Application for Listed Building Consent for replacement of old air extract system with new system.

41 High Street Arundel

NEW AIR-EXTRACTION SYSTEM

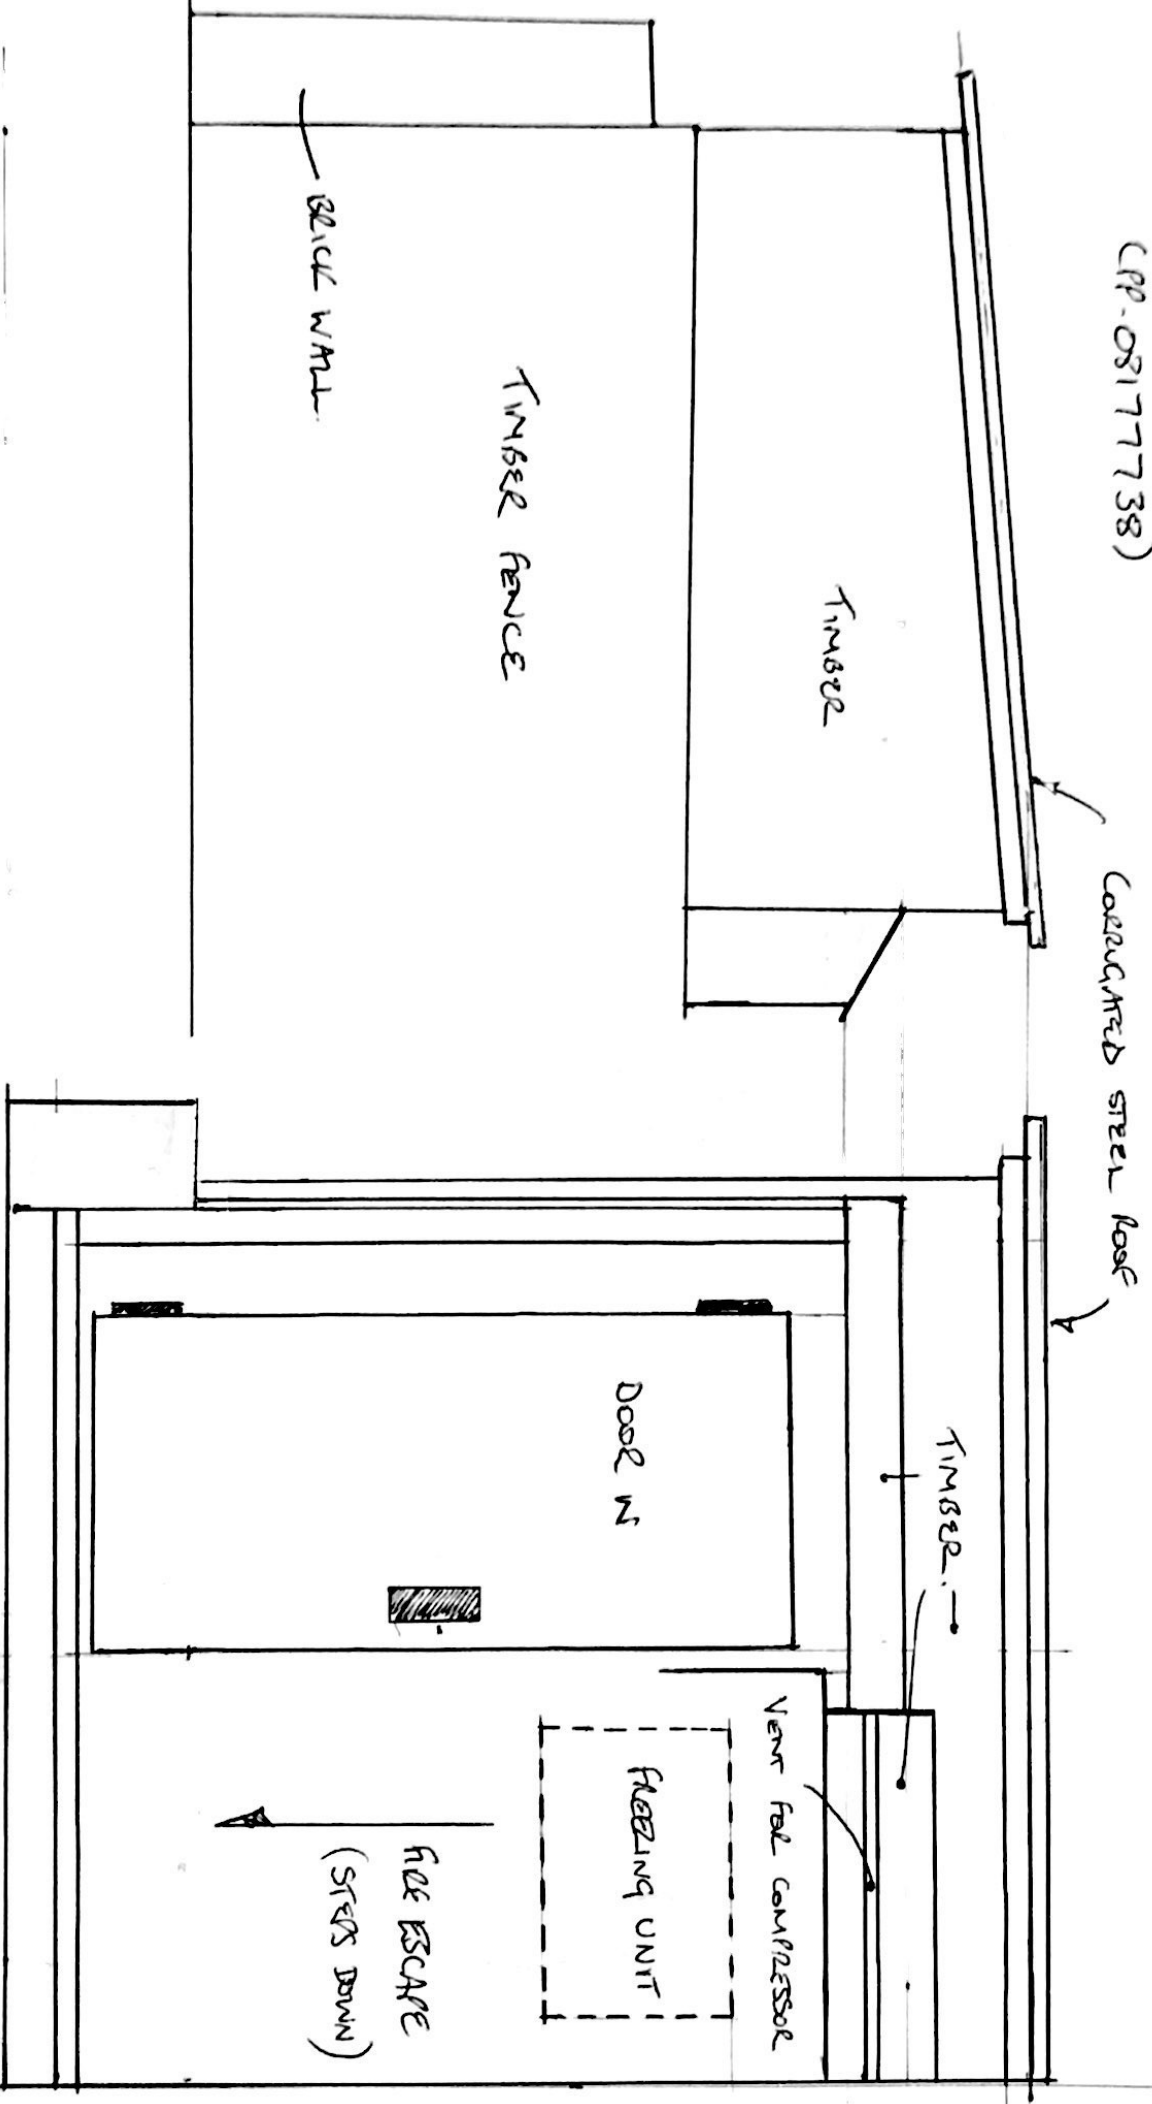
This application for Listed Building Consent relates to the new extractor flue only. Restaurants and cafes are now significant uses in the High Street and must surely make a major contribution to the viability and vitality of the town centre. As such it must be accepted that to maintain these uses paraphernalia such as extraction flues will have to be sited somewhere within their curtilages and very often on their rear elevations. Every effort, though, should be made to reduce the visual impact of flues and as mentioned in the Panel's comments on planning application number AB/112/19/PL it is considered that the flue should be painted white to match the background walling.
